**Subject:** VA-26-00001 Regan - Notice of Application

## **Subject: Zoning Variance application: VA-26-00001 Regan Setback**

**TO:** All Staff  
**FROM:** Public Works Plan Review Team  
**DATE:** February 18, 2026  
**SUBJECT:** VA-26-00001 Regan

Regan, Tracy
1011 Sky Meadows Dr., Cle Elum, WA
Parcel ID: 116734
Map #: 19-16-17050-0003

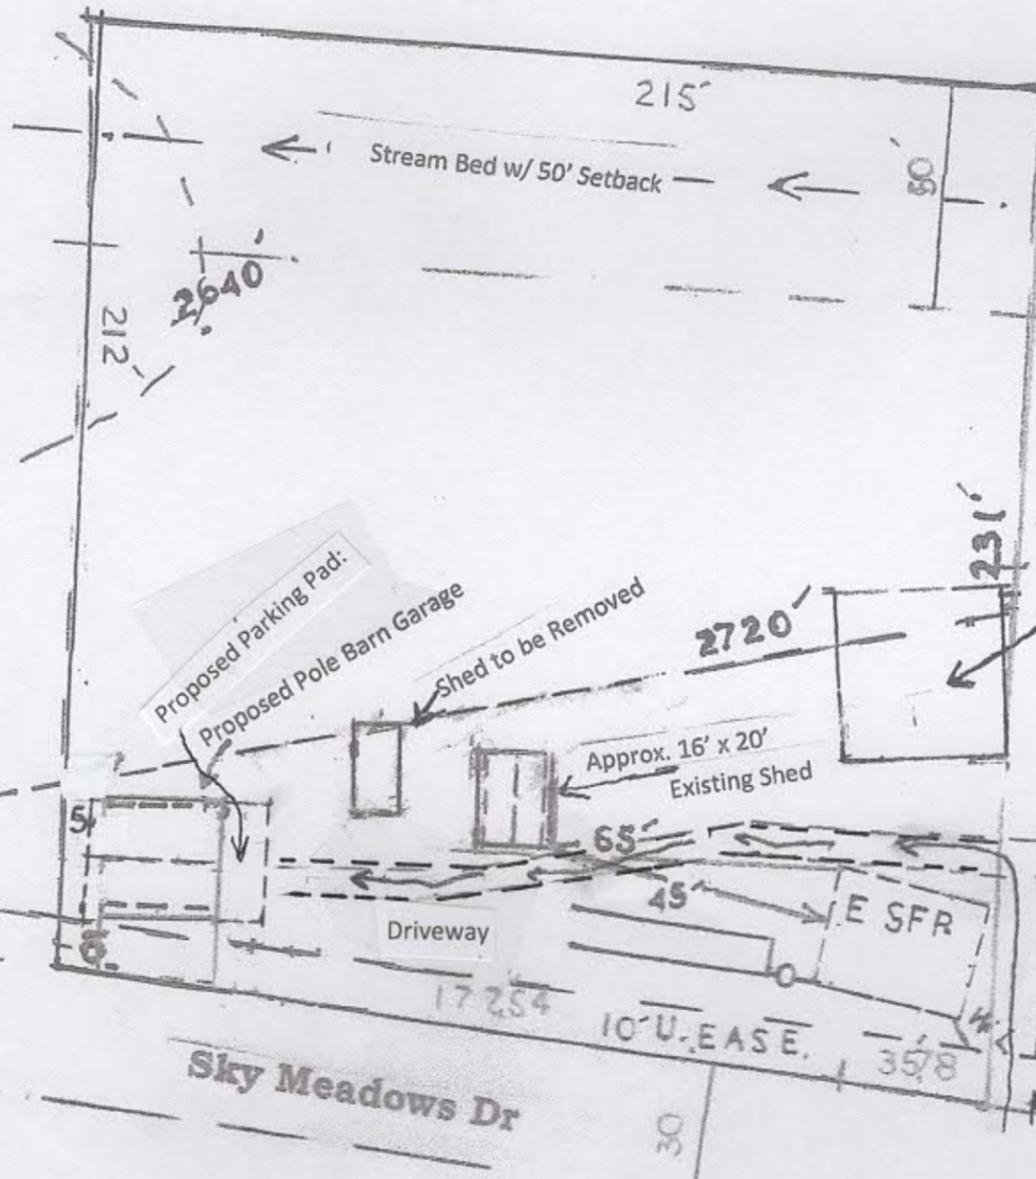
Kittitas County Fire District #7 has reviewed the variance request proposing a reduction from the required 15-foot side lot line setback to 10 feet, and a 15-foot reduction from the required 25-foot front line setback. If approved, this variance would result in a 5-foot side lot setback and a 10-foot front lot setback for the construction of a detached pole barn/garage. After careful consideration, we do not support the approval of this variance due to several public safety concerns.

A 5-foot side setback and a 10-foot front setback significantly decrease the buffer between the proposed structure, the roadway, and the neighboring parcel. This limited space may obstruct access for fire apparatus and other emergency vehicles.

Kittitas County is located within a high-risk wildland-urban interface zone. Structures situated closer to the road may be more susceptible to ignition from roadside fires or windborne embers. Reduced setbacks also limit defensible space, which is essential for protecting structures during wildfire events.

We recognize that the County already requires non-combustible Class A roofing materials. However, if the variance is approved despite the concerns noted above, we strongly recommend requiring additional ignition-resistant construction features, including fire-resistant siding and ember-resistant vents, to help mitigate increased risk associated with reduced setbacks.

<b>Drinking Water</b>	<ul style="list-style-type: none"><li>• No comment for dry structure</li></ul>
<b>Wastewater</b>	<ul style="list-style-type: none"><li>• Building foundation setback five feet from septic tank, five feet from property line / easement, and ten feet from drain field</li></ul>

<b>SURVEY</b>	Due to the minimal requested setbacks, it is highly recommended that the building envelope be staked by a professional land surveyor. (JT)
<b>TRANSPORTATION CONCURRENCY</b>	No Comment. (RC)
<b>FLOOD</b>	Parcel #116734 is not within a FEMA identified special flood hazard area (1 percent annual chance flood zone). A floodplain development permit is not required. (SC)
<b>WATER MITIGATION/ METERING</b>	No comments. (SC)
<b>AIRPORT</b>	No Comment. (RC)
